## Conservation Consultation Response:

<b>From:</b> Ian Heywood Planning Conservation Officer		<b>To:</b> Lucy Lowcock DM Case Officer
<b>Application no.</b>	20/00953/FUL	
<b>Location</b>	1 - 7 Lord Street Fleetwood Lancashire FY7 6DX	
<b>Description</b>	Alterations to entrances and windows	
<b>Date</b>	14.01.2021

Dwg No: AL-20-001
Dwg Name: Proposed Ground Floor

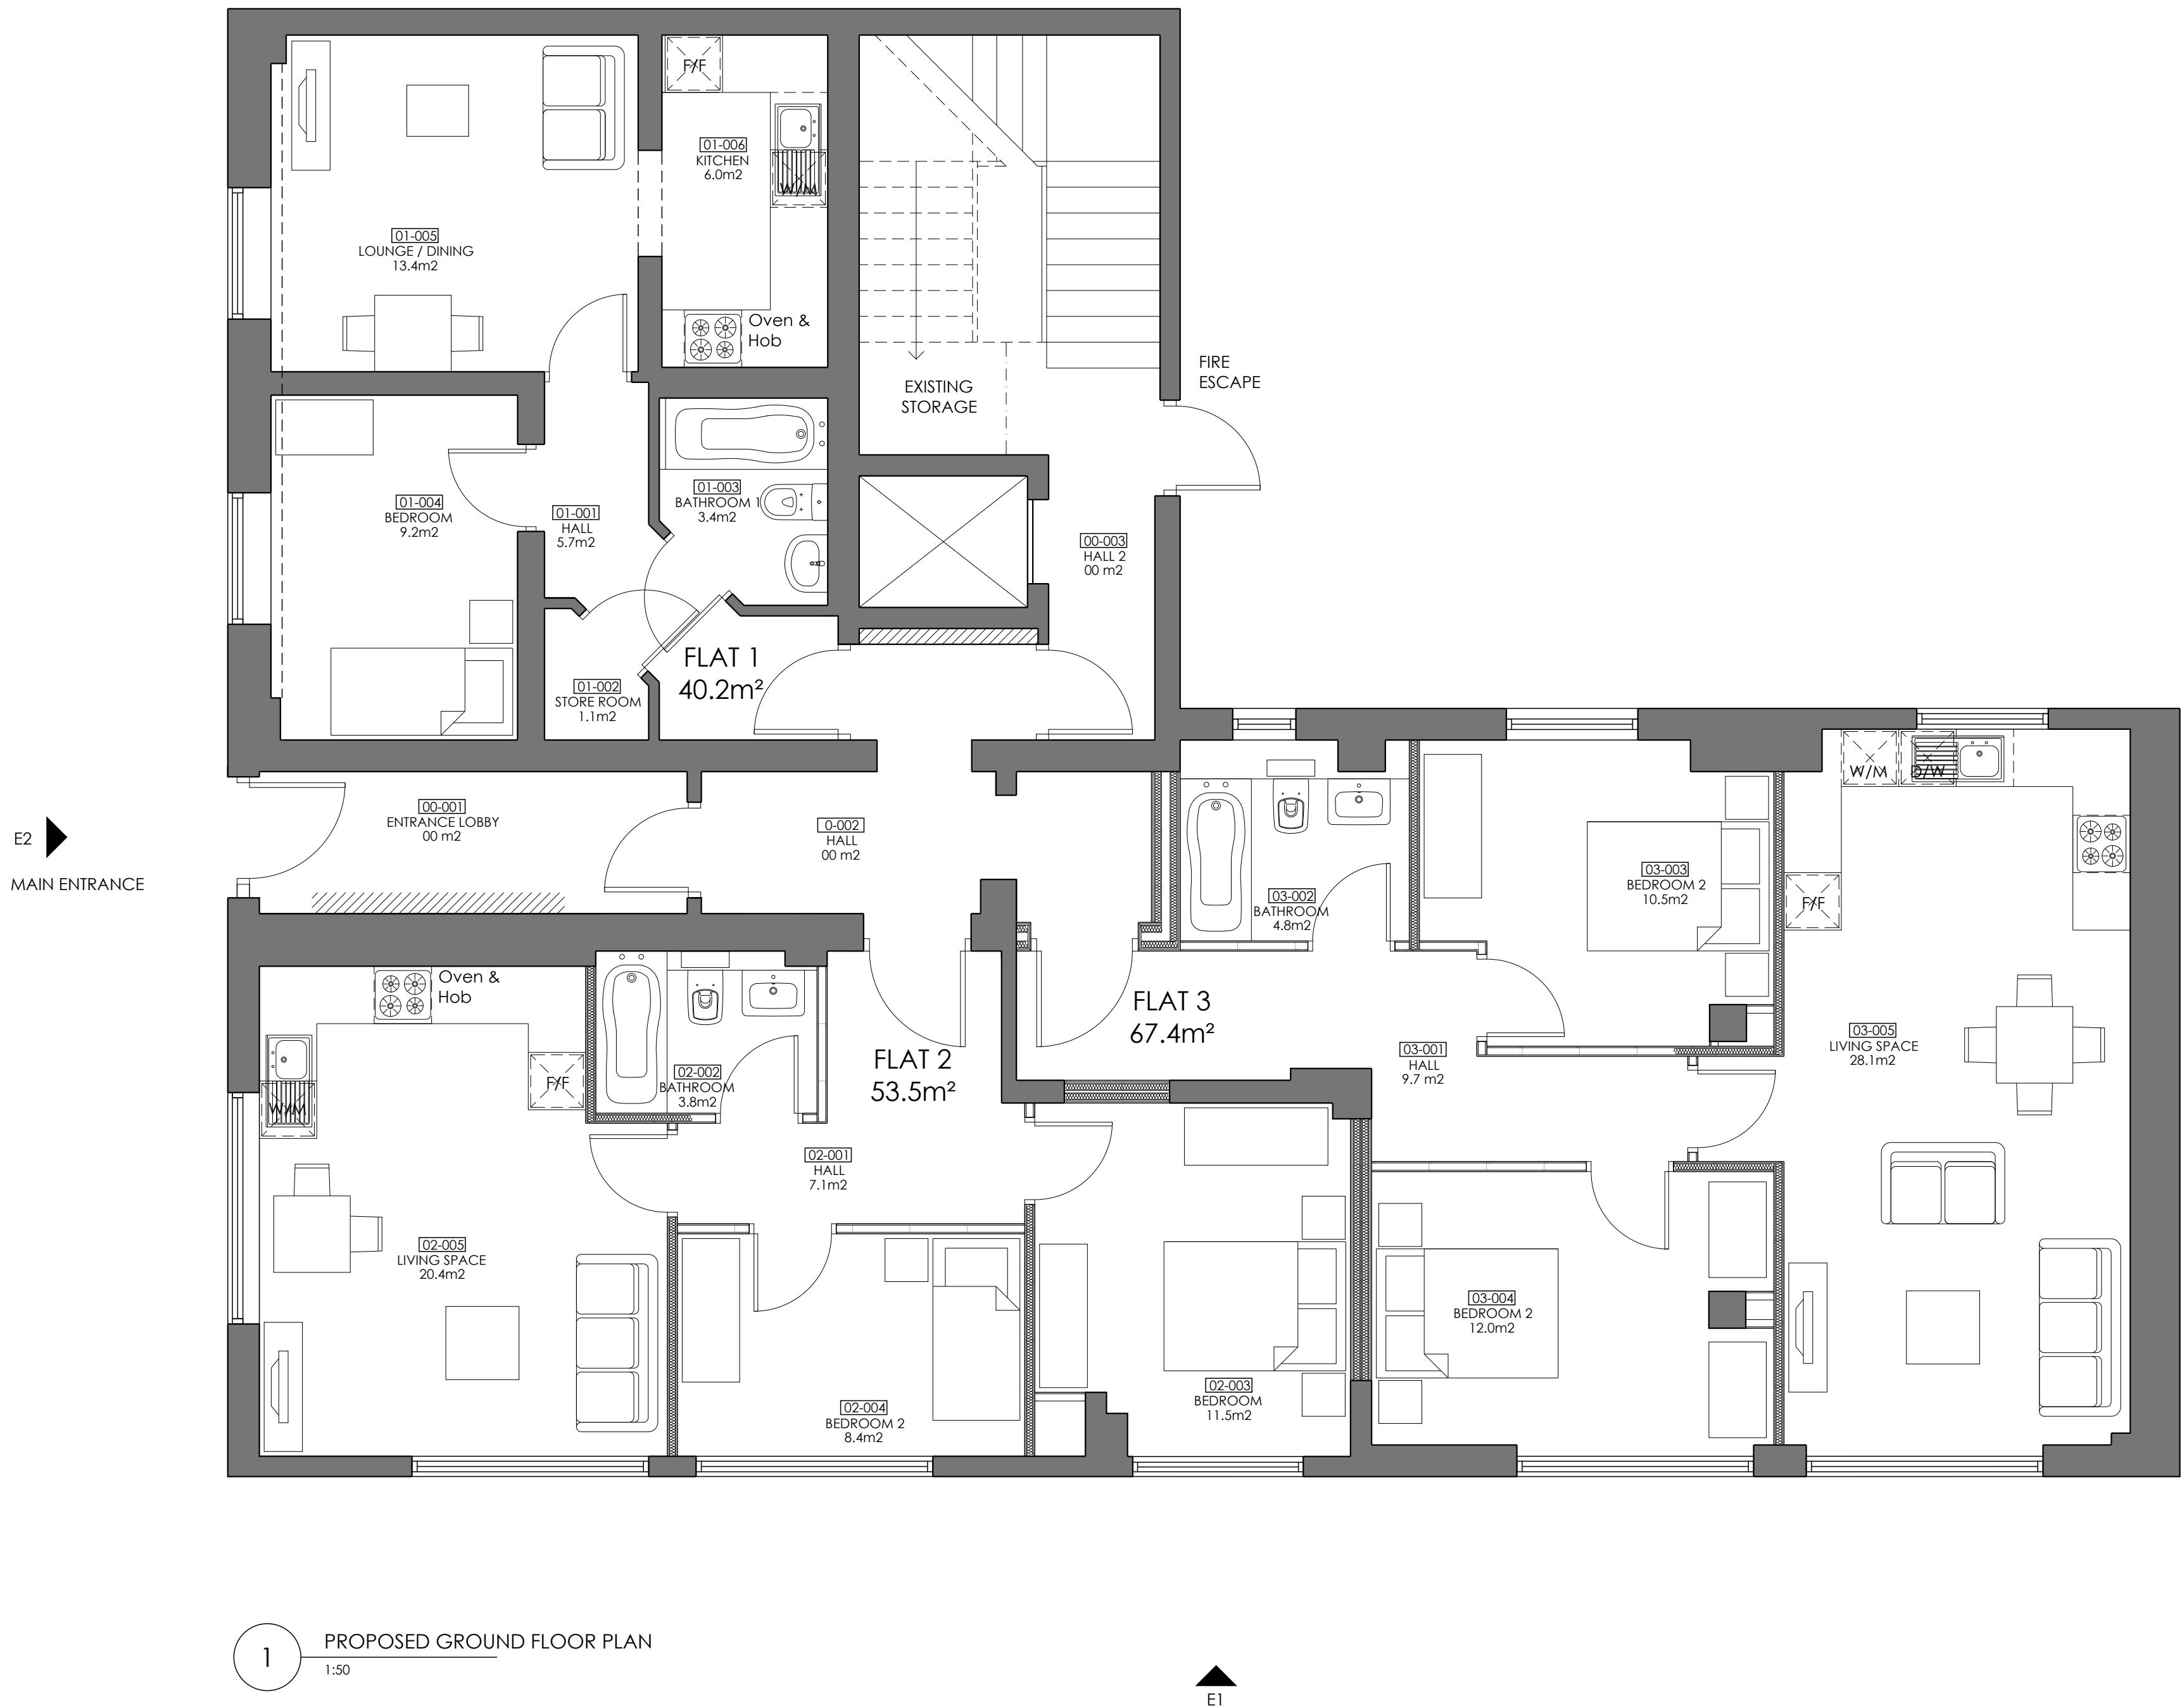
The only slightly jarring element is the proposed window WG06 to elevation E1 and the existing, proposed main, entrance door to elevation E2. These have their heads set at a height that is considerably lower than the adjacent windows and as a consequence upset the otherwise equal rhythm of openings on each of the principal elevations. This would be improved by raising the height of both by adding what in effect would be a fan light to the principal entrance door and by raising the height of proposed window WG06 to the same height as the adjacent windows. In my view these small changes would considerably enhance the appearance of the building.
